**REQUEST**

Current Zoning: R-6MF(CD) (multi-family residential, conditional)  
Proposed Zoning: R-22MF(CD) (multi-family residential, conditional)

Approximately 14.8 acres located on the west side of Krefeld Drive, east of Monroe Road, and west of East Independence Boulevard

The petition proposes to develop the site with up to 320 multi-family dwelling units on the vacant site in southeast Charlotte, east of McAlpine Creek Park.

**RZ-1.0**

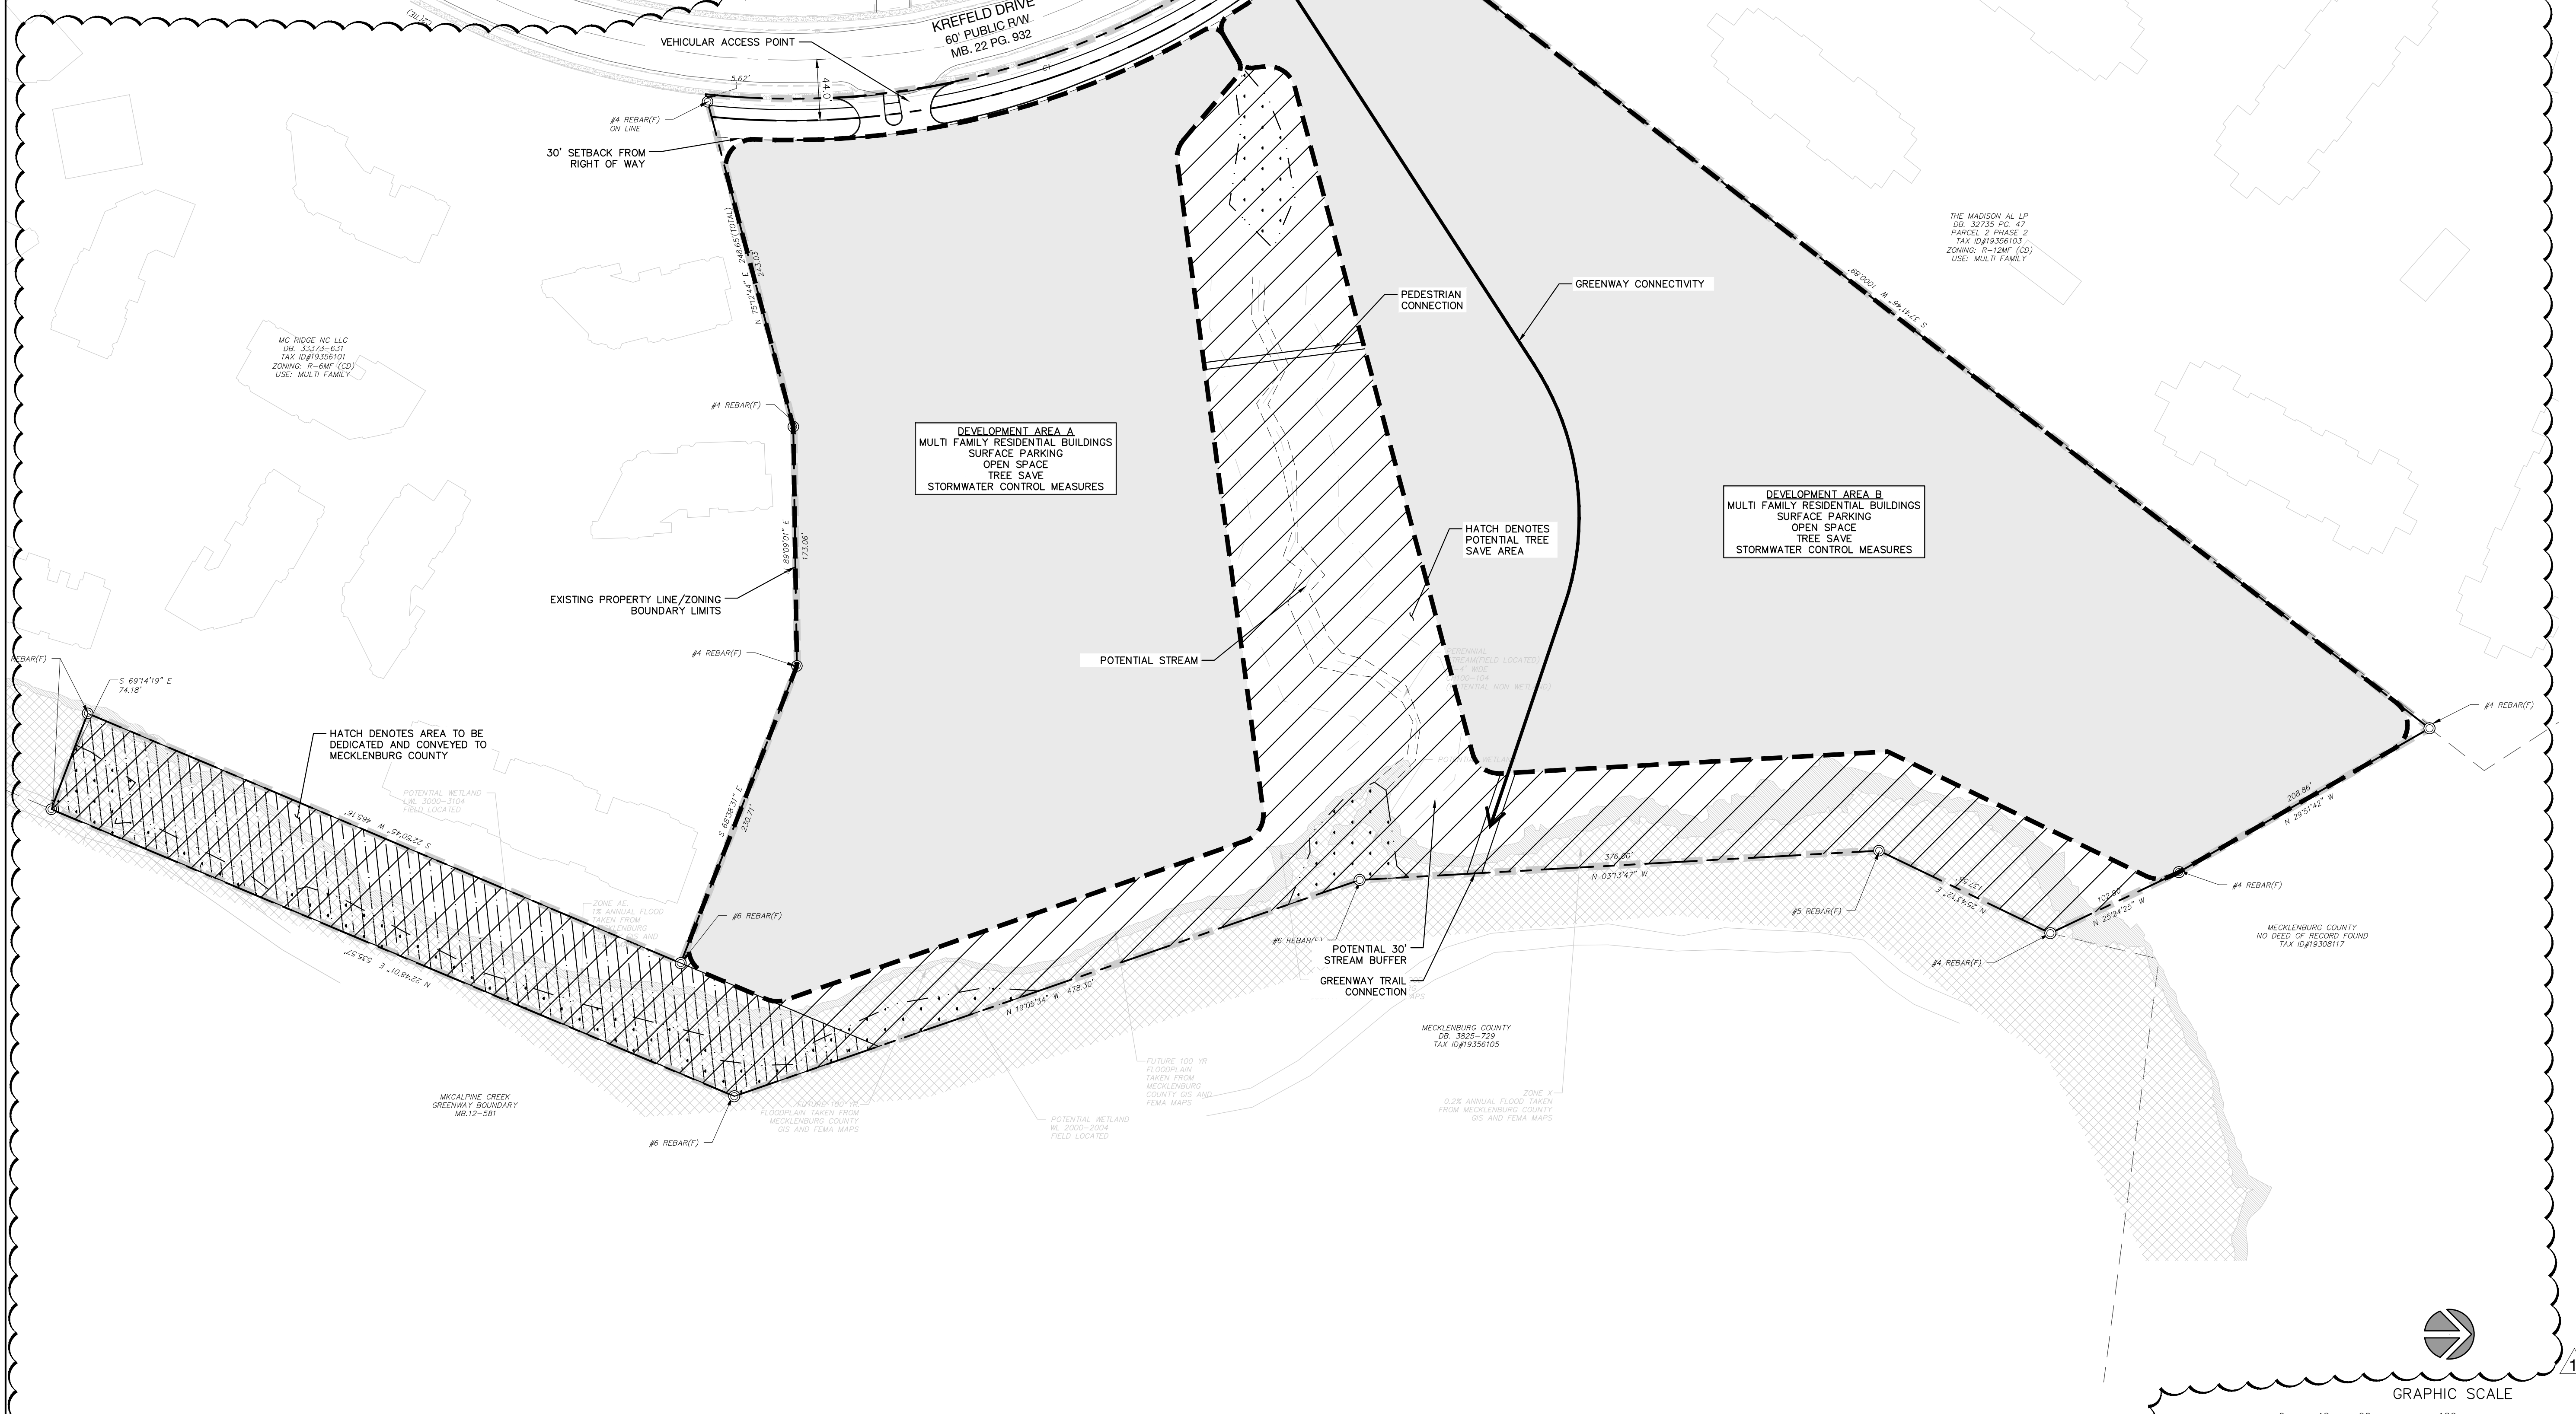
3. Adjust north arrow to match site orientation. Addressed.
4. Amend Streetscape, Buffers, Yards, and Landscaping Note 4 to state the "Solid waste facilities will be provided as required by Solid Waste, exact locations to be determined during permitting." Addressed.

5. Amend the Development Data table to include the minimum % of open space required. Addressed

RZ-1.0

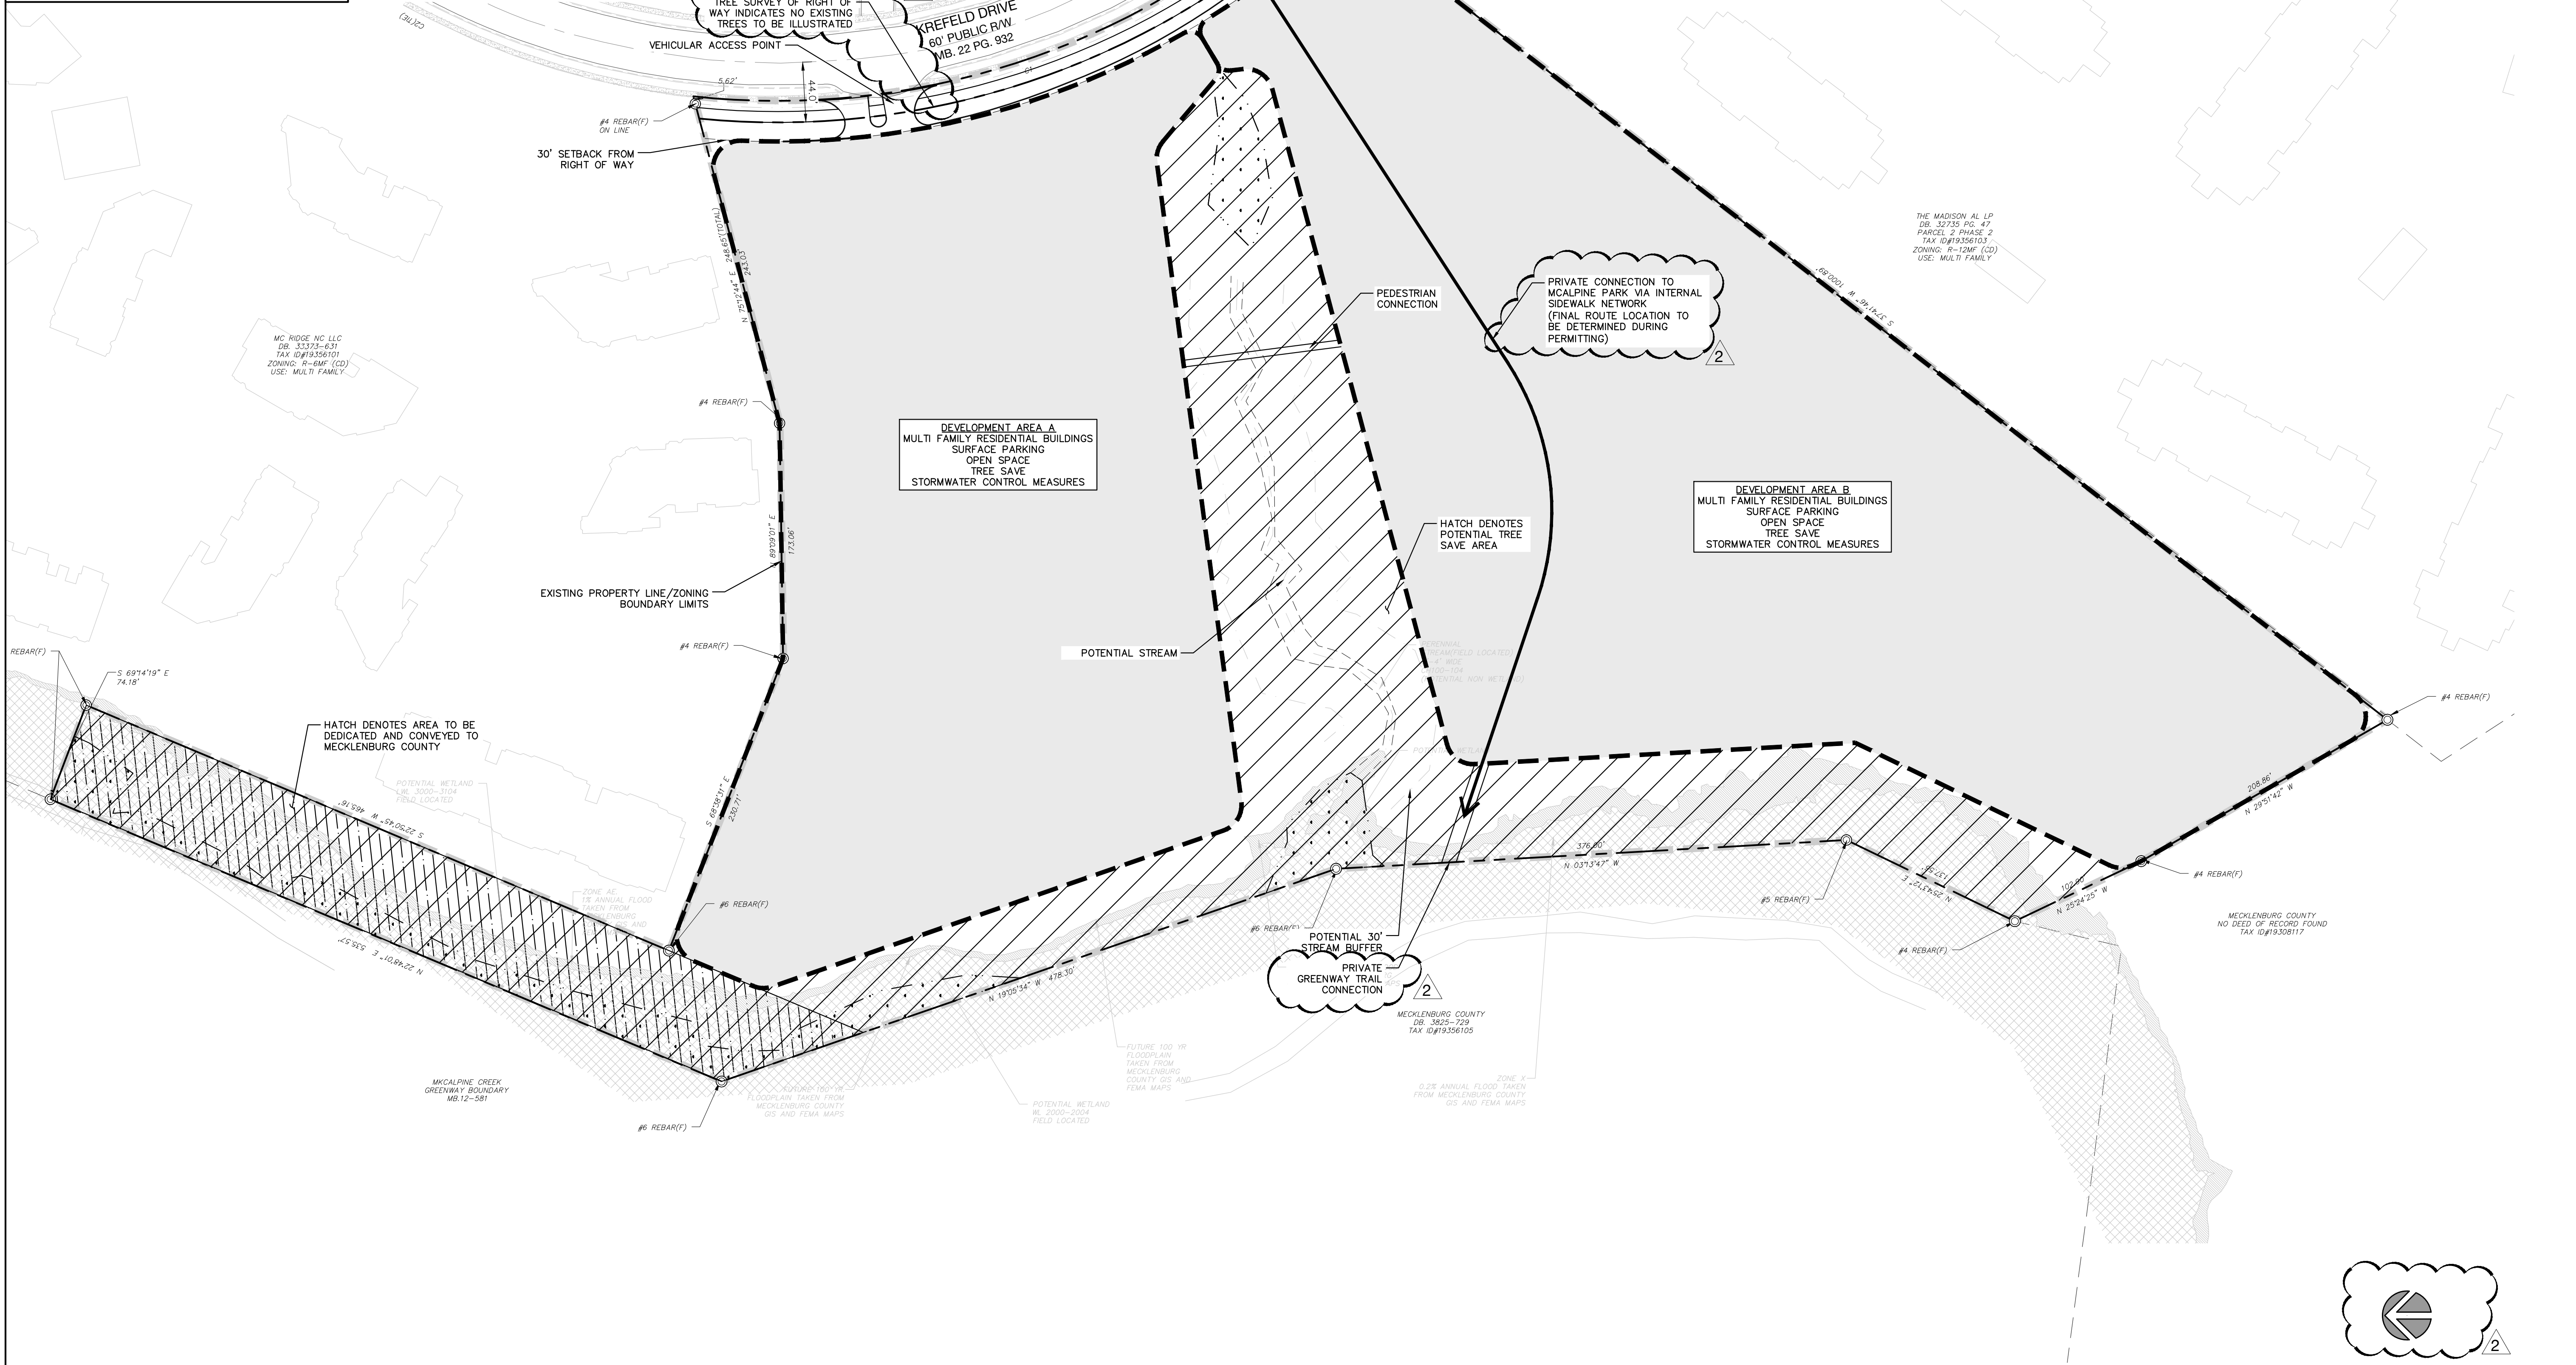
2. Clarify intent of trail connection shown on plan and noted in Park Dedication Note 1. The way the note reads now it sounds as if only residents of the proposed project would be able to use the connection. Planning staff requests the note be revised to include a public access easement so other residents along Krefeld could access the park. Addressed, the plan clarifies that connection to the McAlpine Creek Park boundary utilizes the proposed internal sidewalk network not intended for public use/access. Planning staff rescinded the request for public access after communication with Mecklenburg Parks and Recreation and confirming that the connection would be similar to the connections at the adjacent existing multi-family developments.
